Re: Proposed Detached Bungalow and Detached Garage.

At: 25 Clough Road, Hoyland, Barnsley. S74 9EA.

For : Mr. & Mrs. A. Slater. Application No: 2019 / 0757.

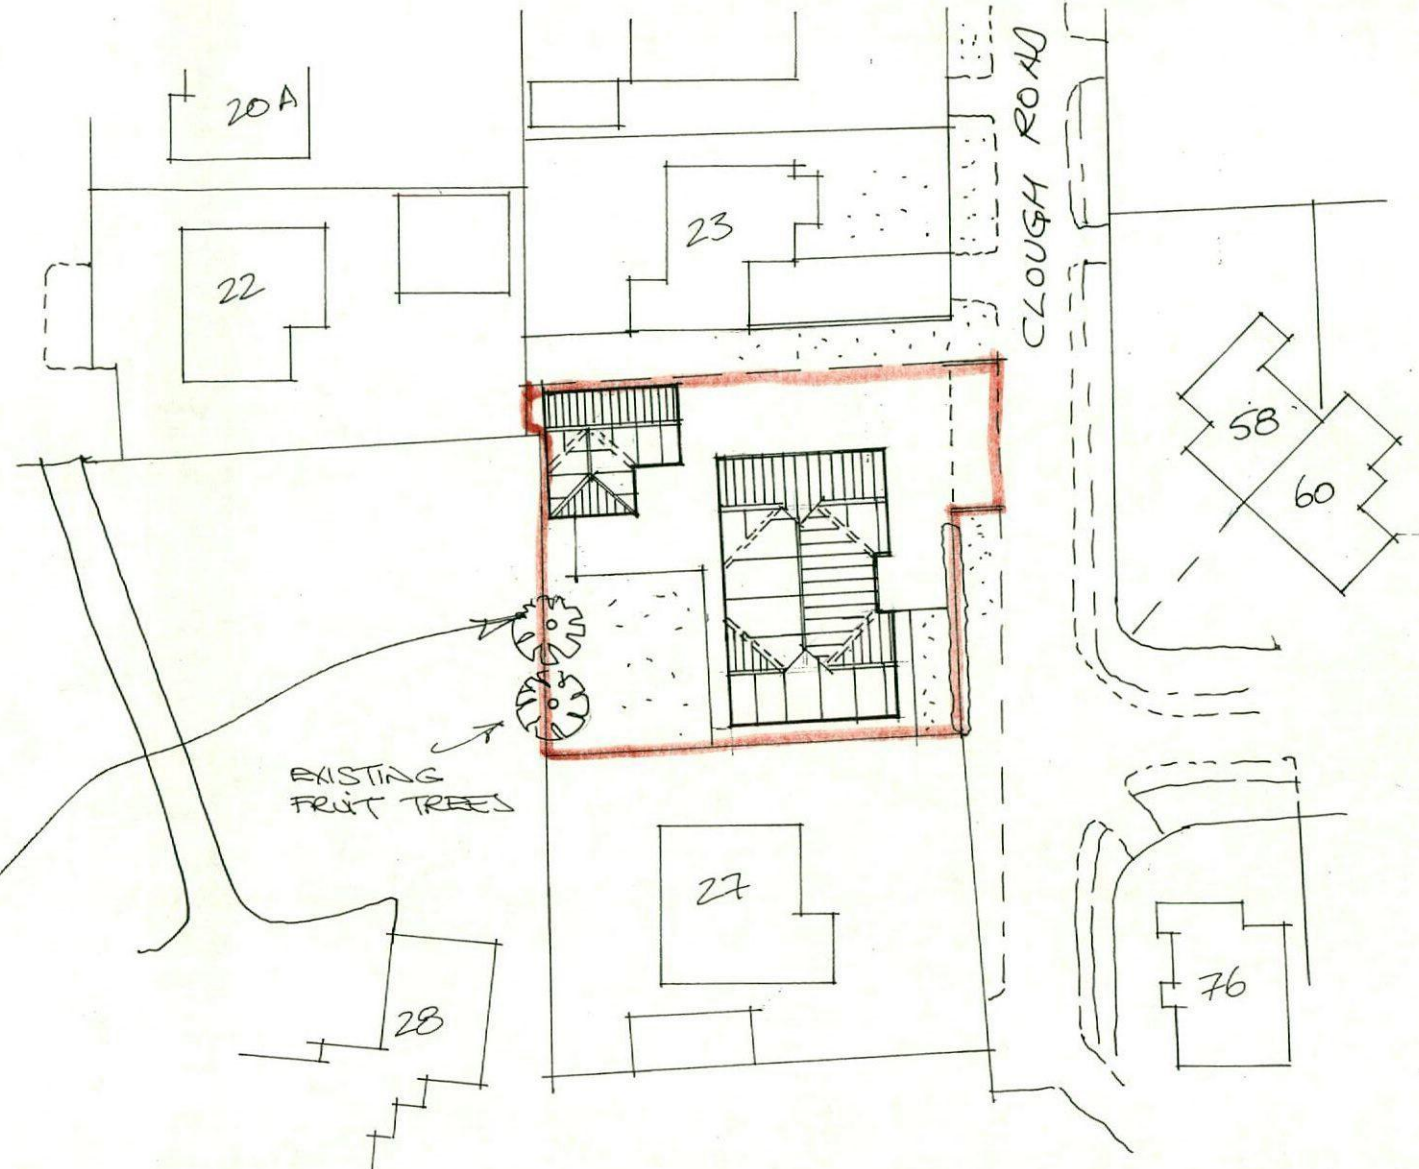
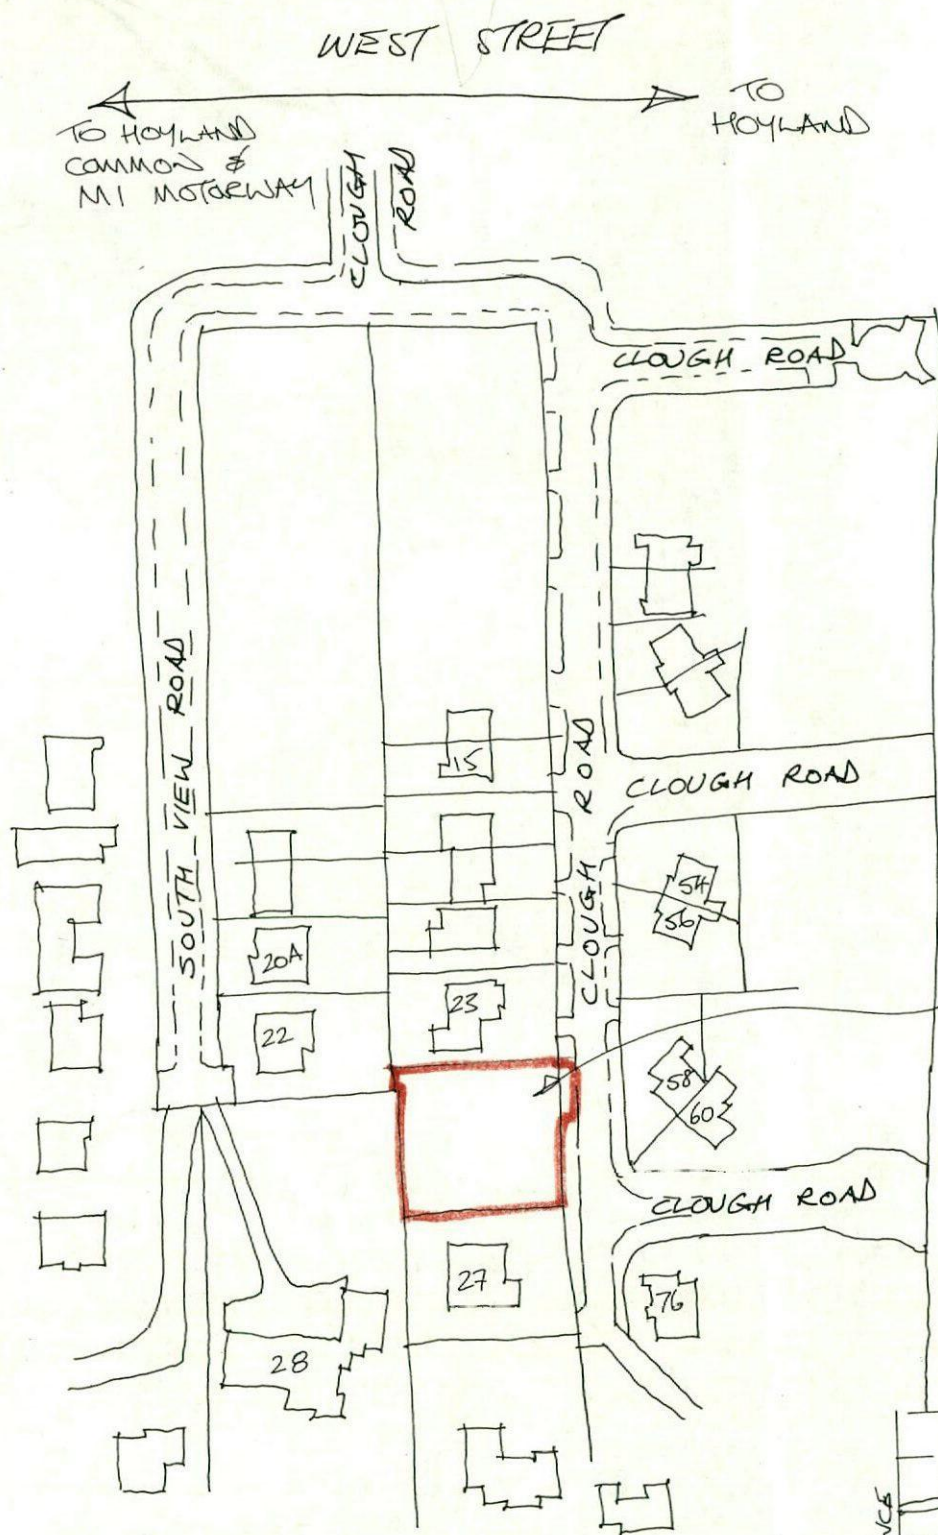
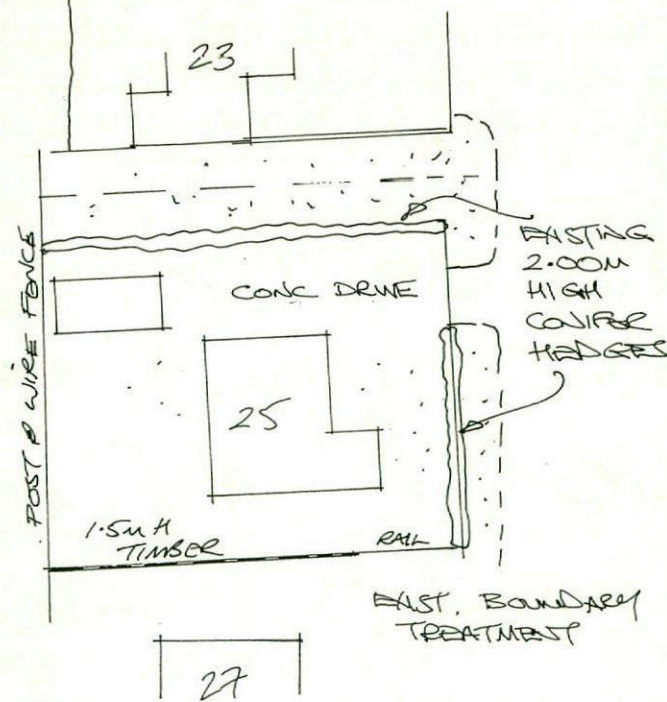
- i) Set the Bungalow back on the land by 2.0m;
- ii) Omit both the play and wet rooms from the detached garage; reduce the length to 7.00m; provide hipped end to the rear to lower the impact.

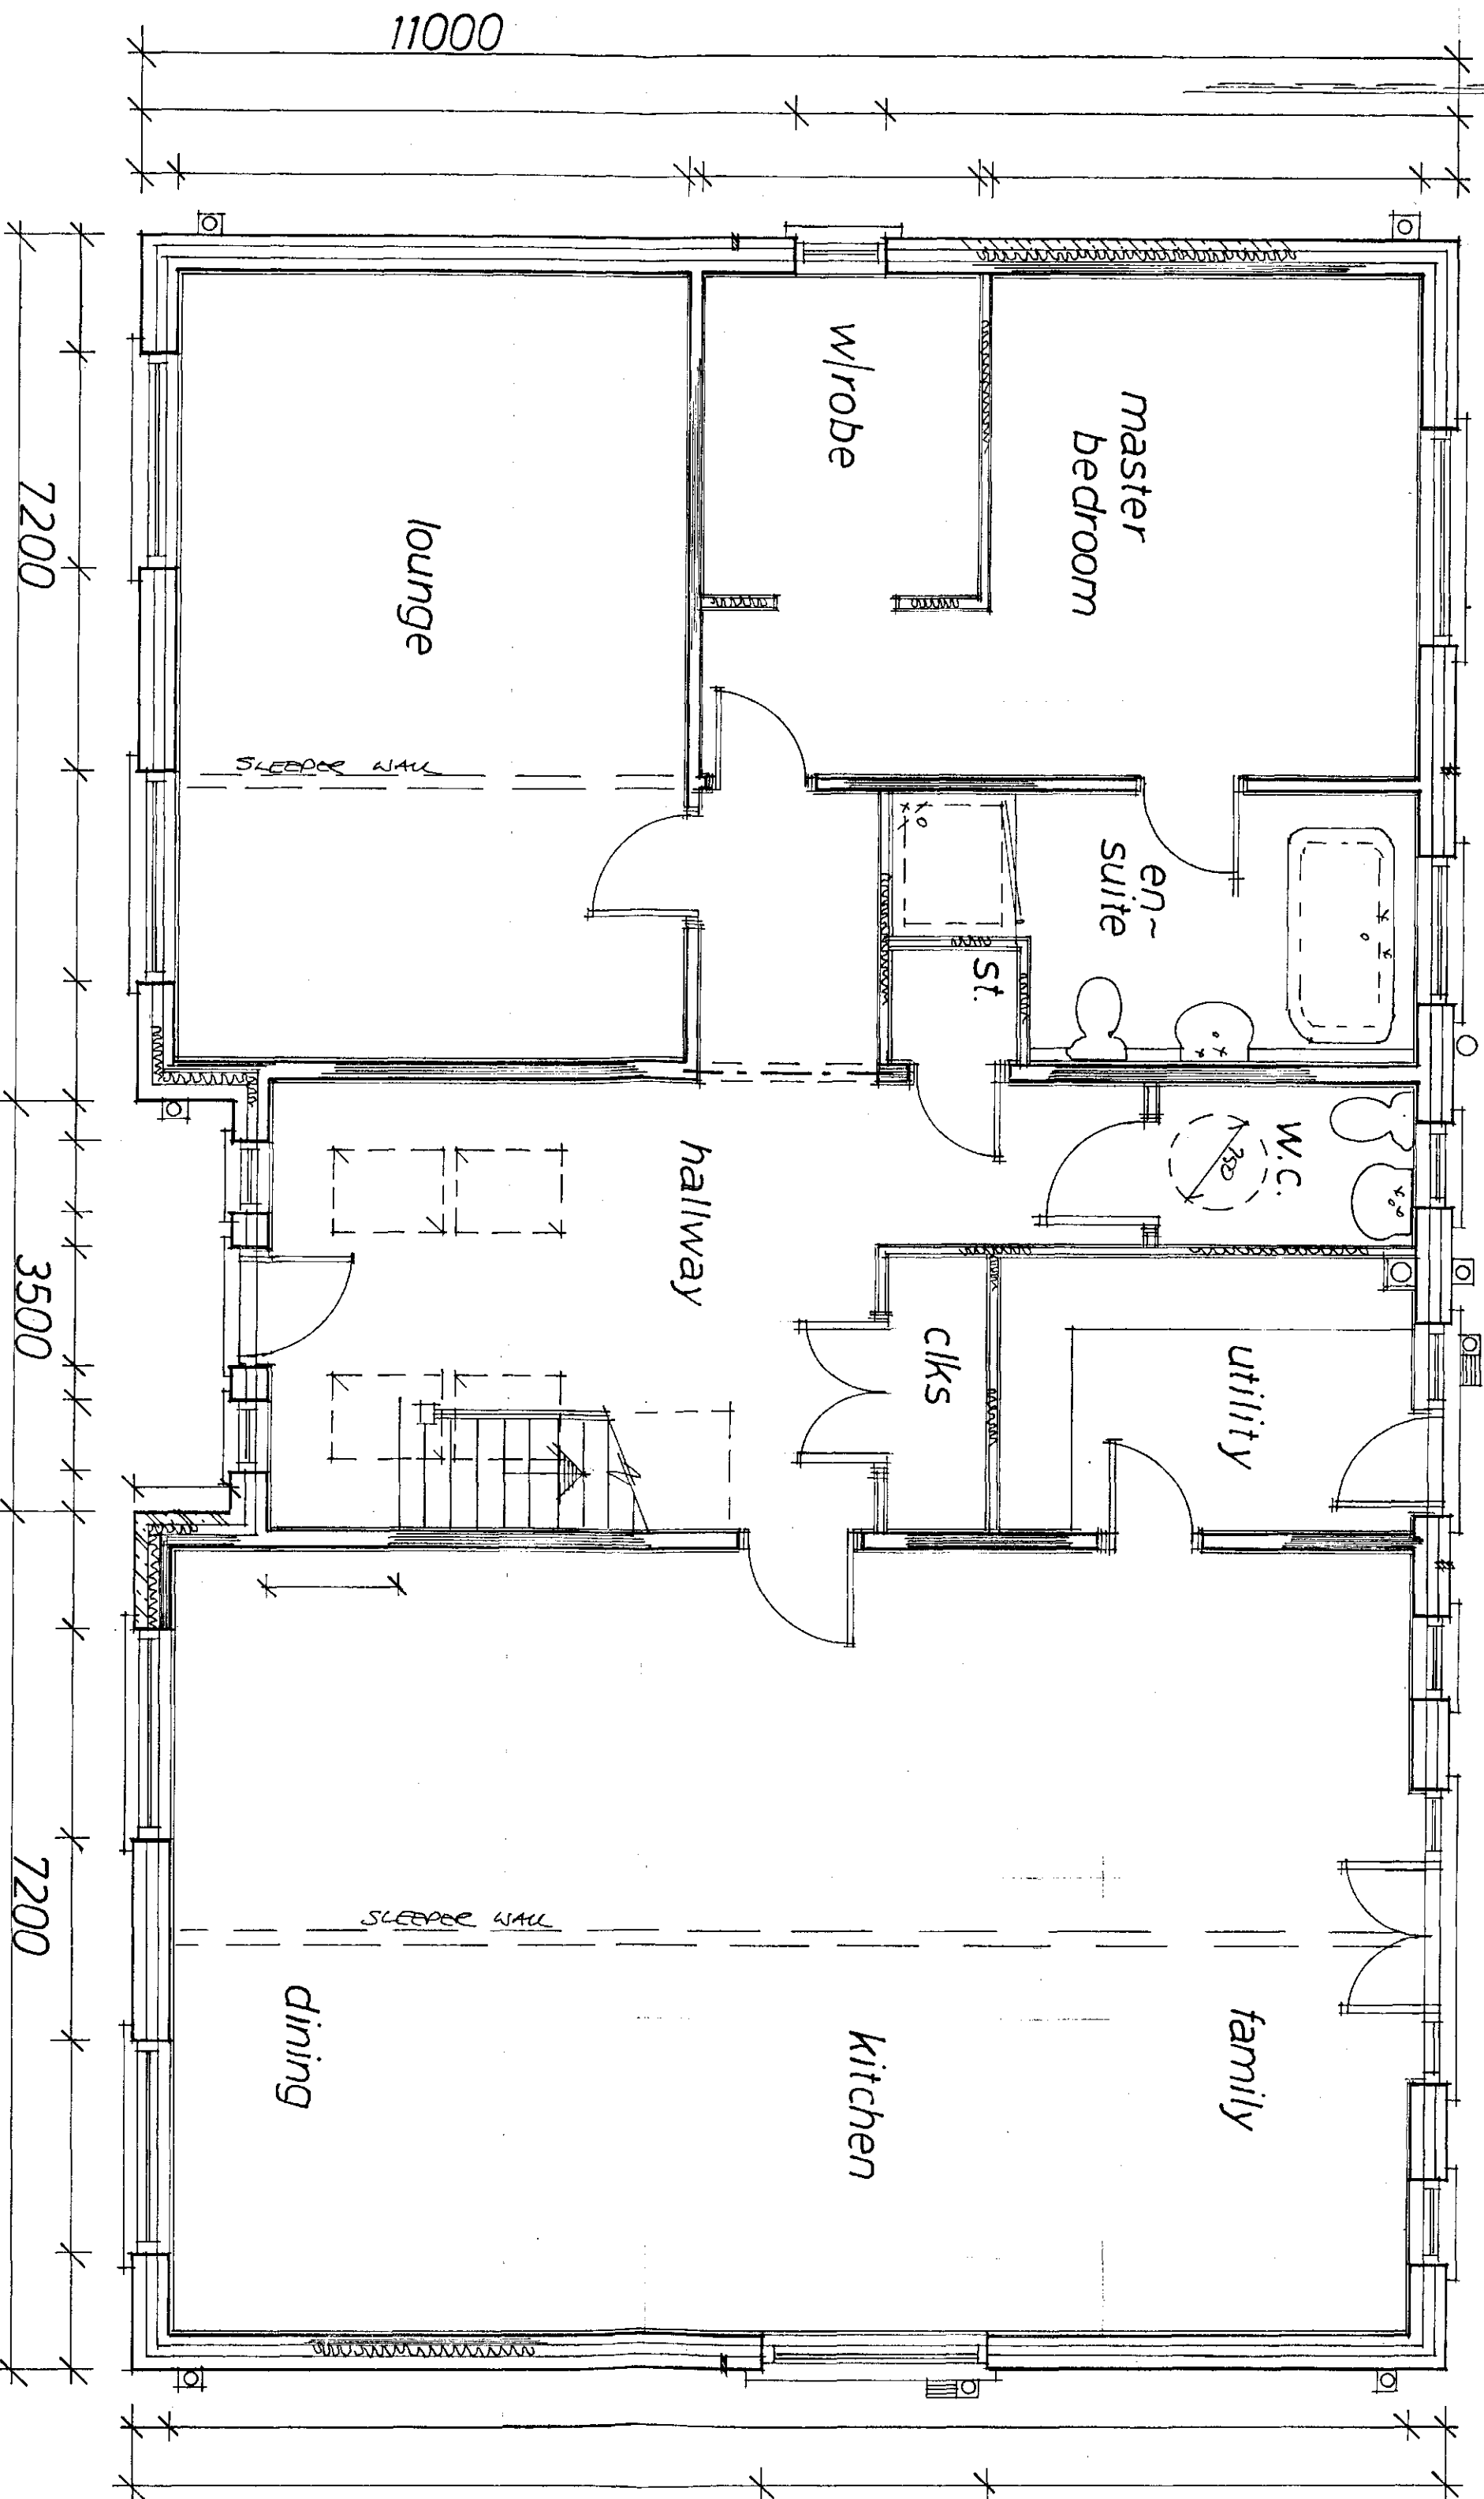
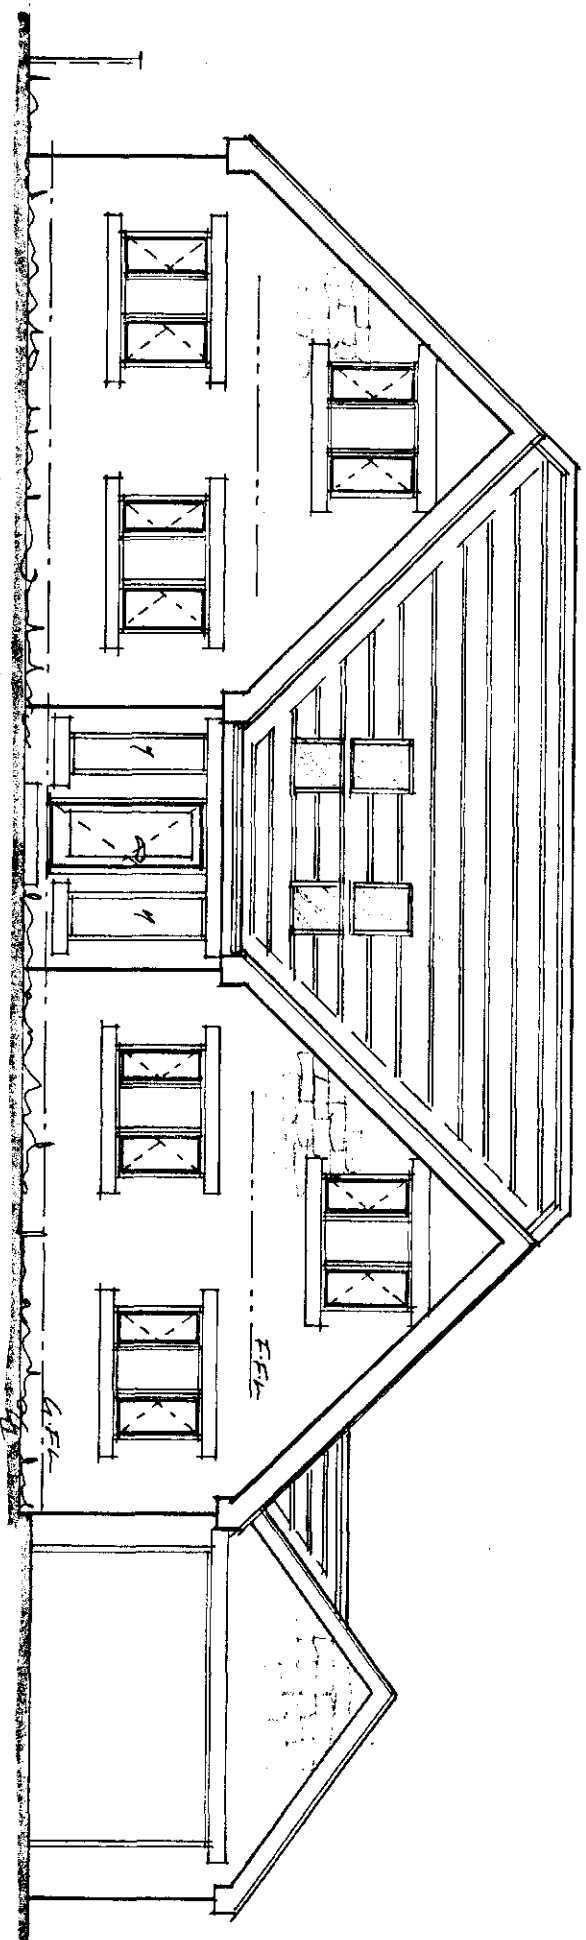
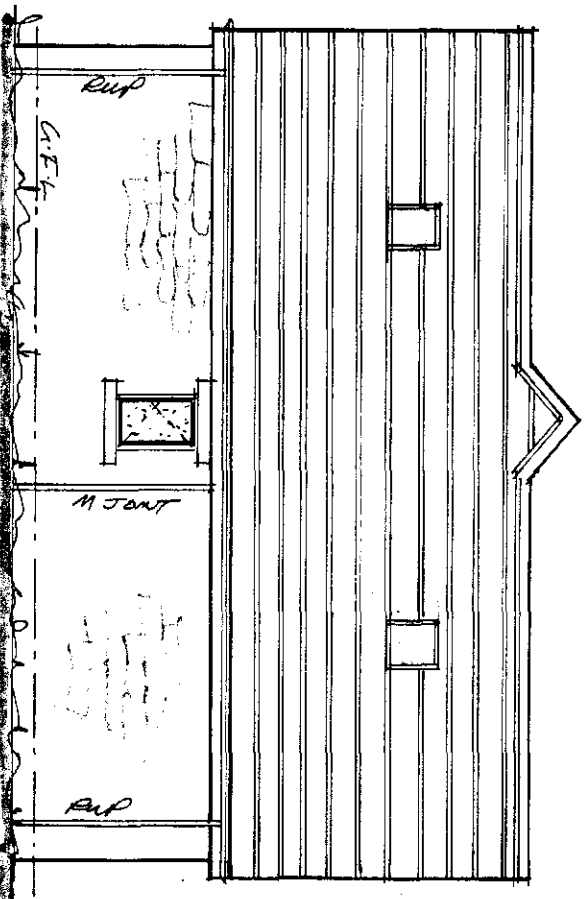
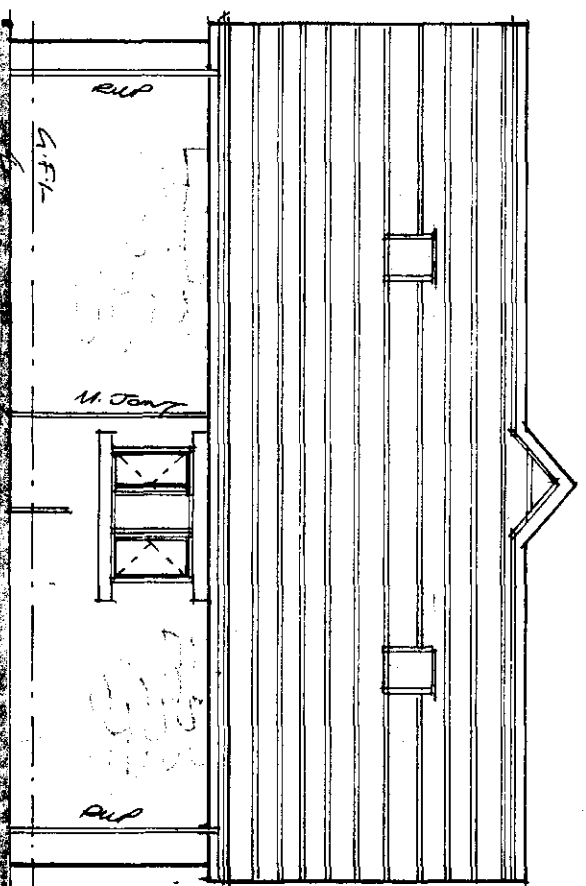
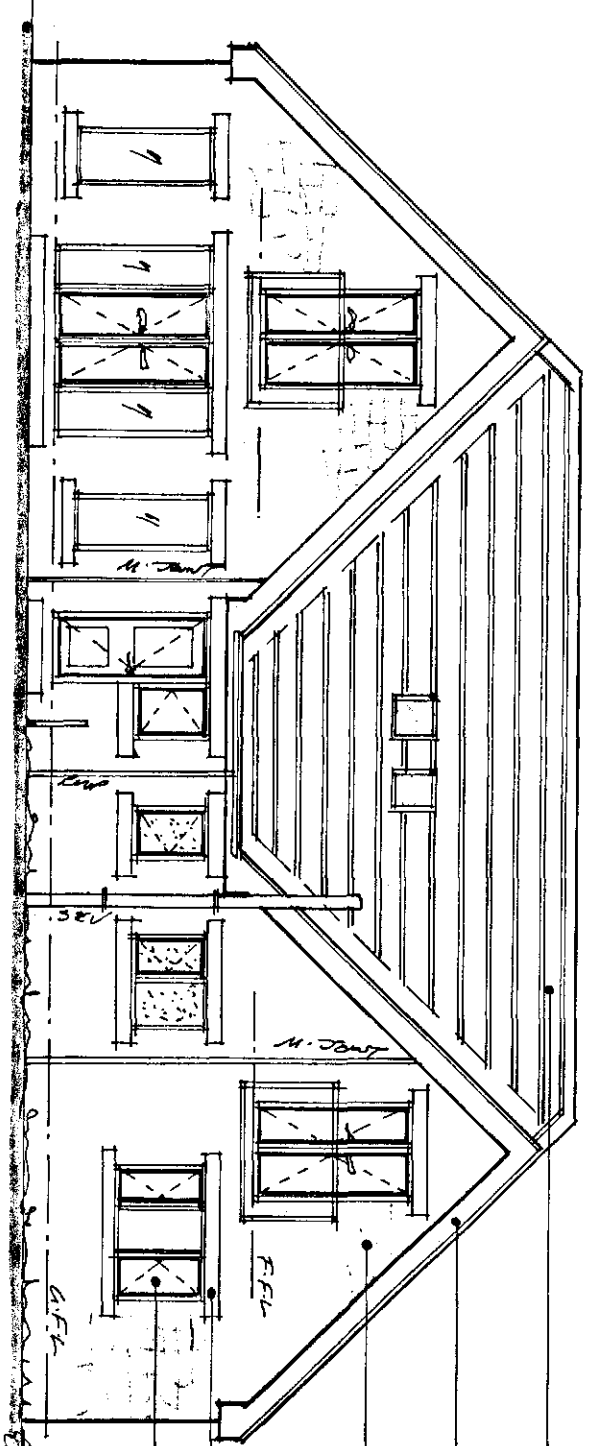
With regards to the height of the main bungalow, if we were to reduce the overall height somewhat, then this would compromise the headroom to the first floor accommodation (and reduce these bedroom widths also) so the height will remain.

However after speaking to both the client and the main contractor, due to the existing slope across the land, by the use of nominal retaining walls, we would be able to reduce the overall external ground floor level around the bungalow by approx. 350mm to 400mm.
